To: Eoin Hickey
Cc: Ben Lusher
Subject: RE: SSD 15_7317 - Public response to Development

June 21 : 9.00am

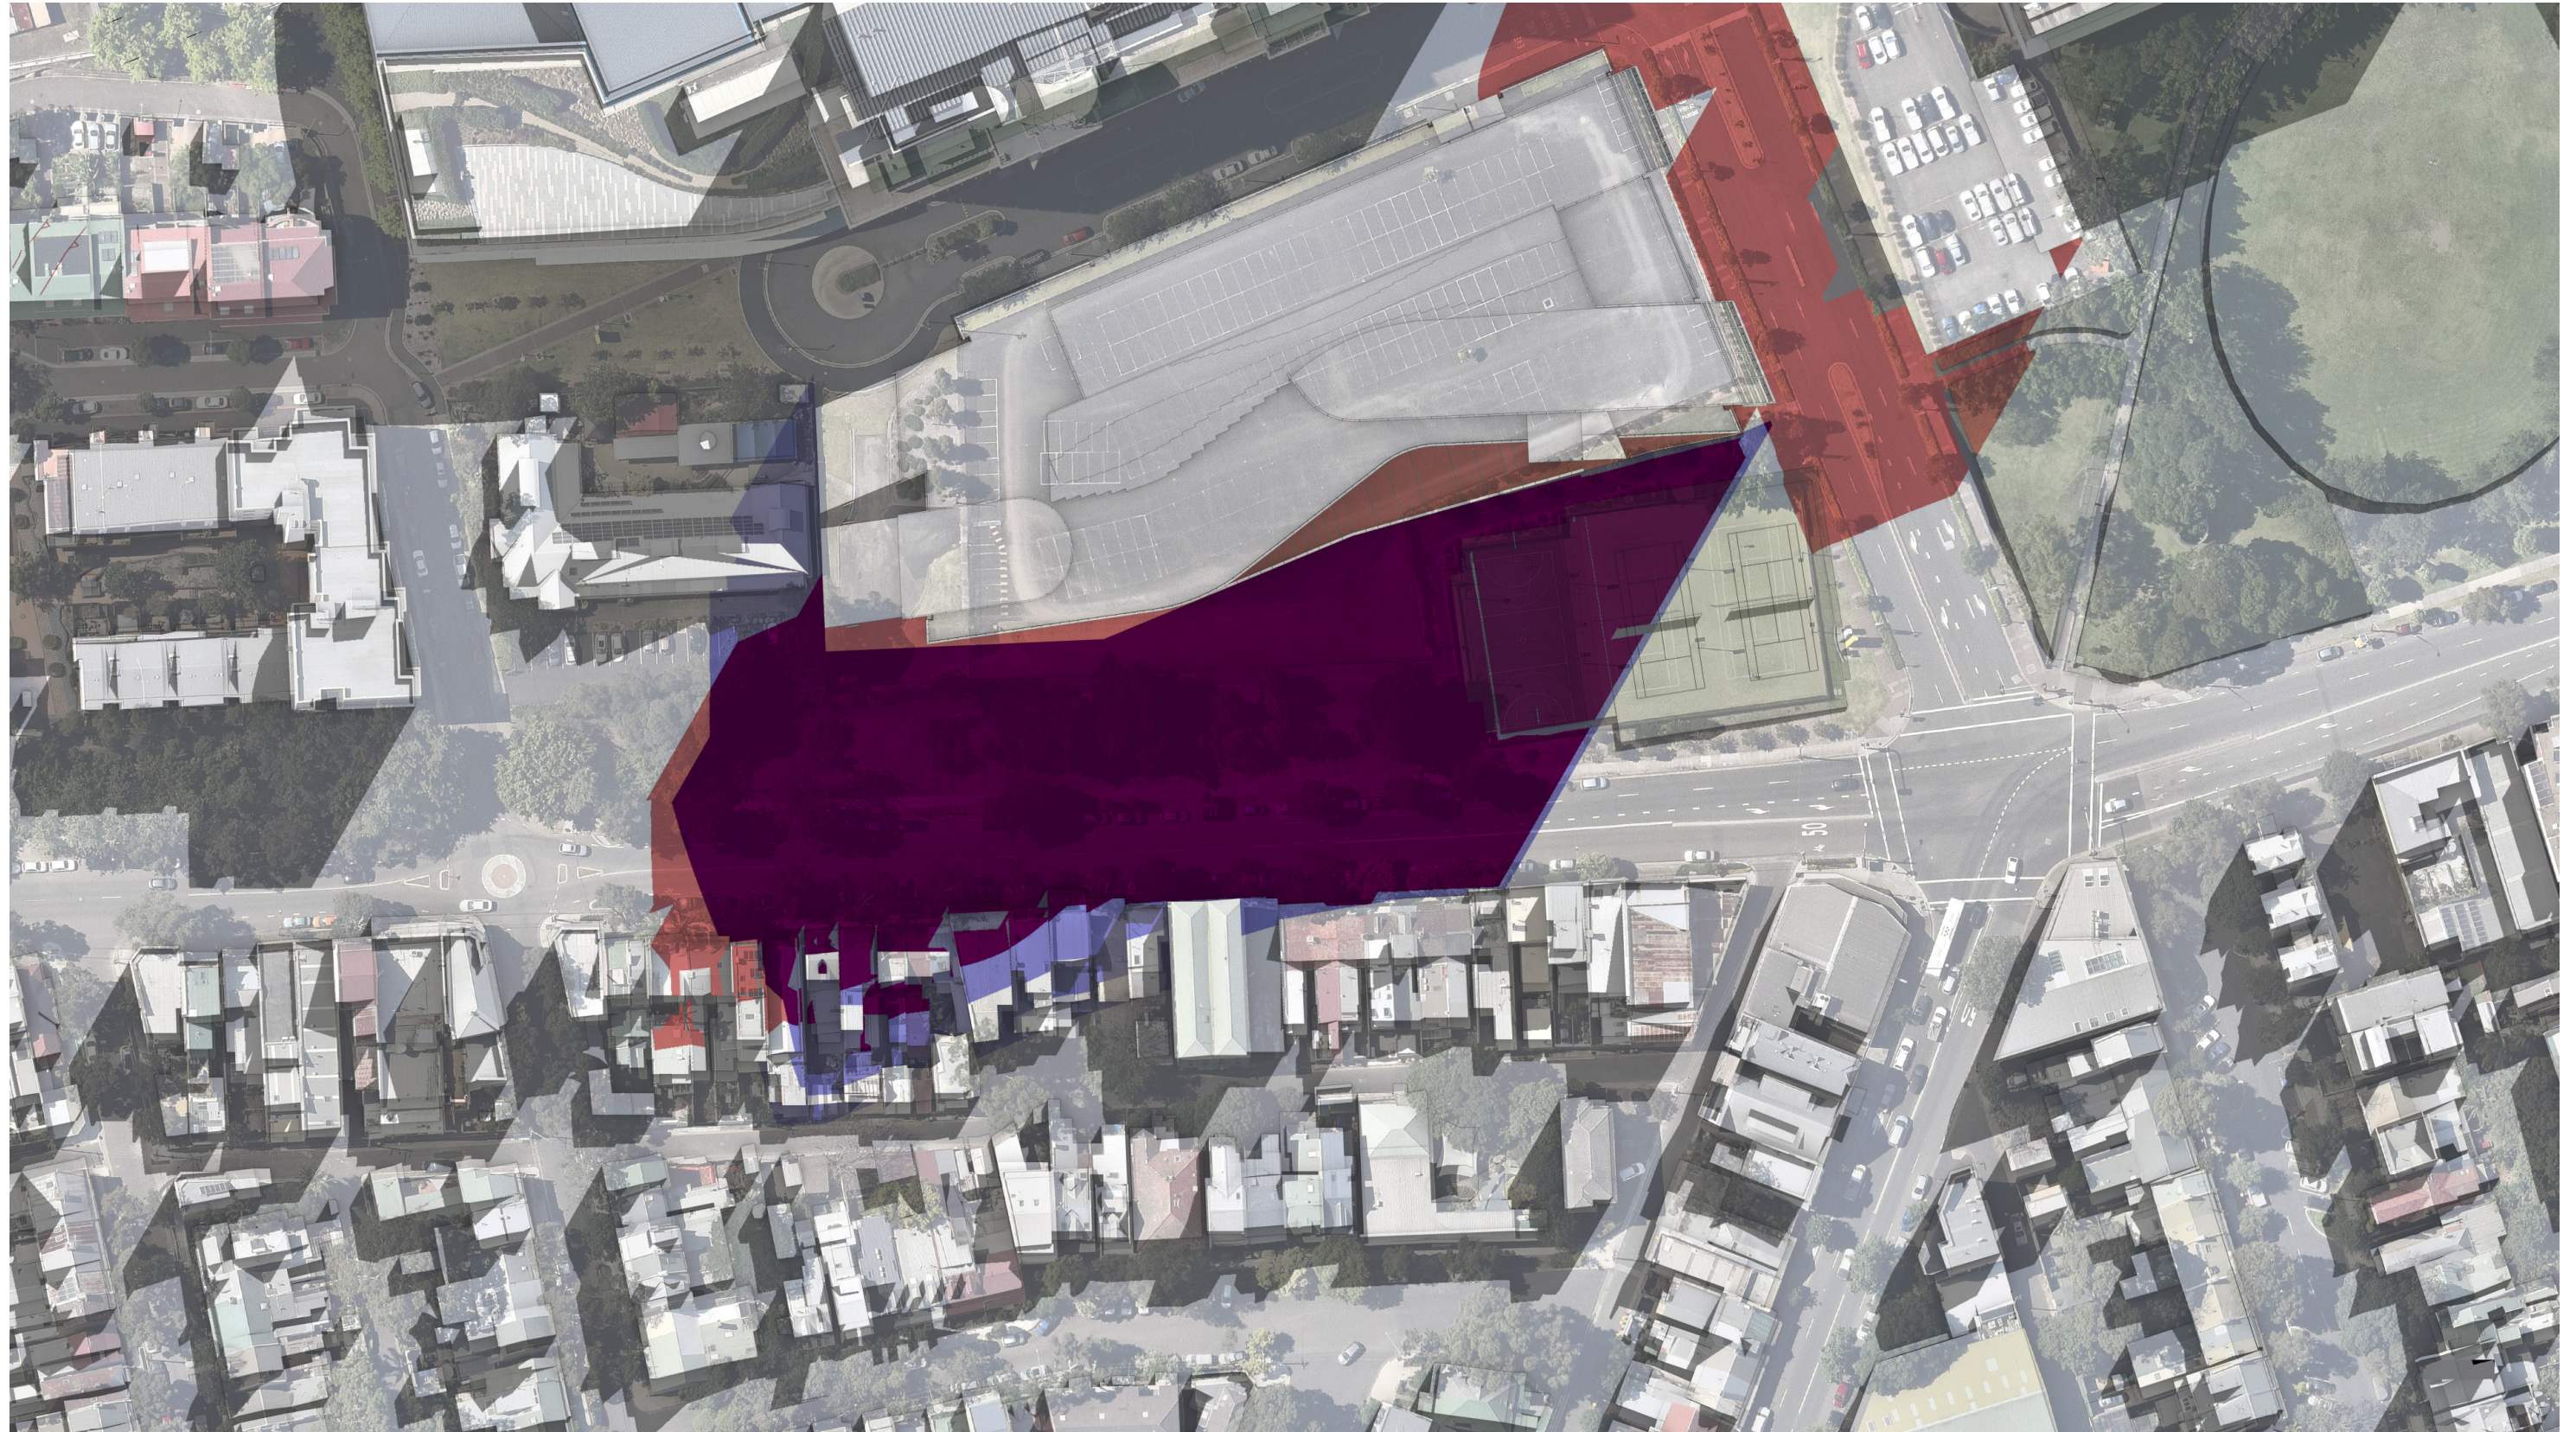
Finally, outdoor play areas of child care centers are designed so as not to be overlooked by adjoining properties. A 50 plus metre building towering over the child care outdoor play area was not responded to appropriately despite the risk to the children and carers safety and privacy both during and after construction while highlighting that the existing Channel 7 building is already impacting the local surrounds is not a valid argument for allowing the development to go ahead at the proposed height.
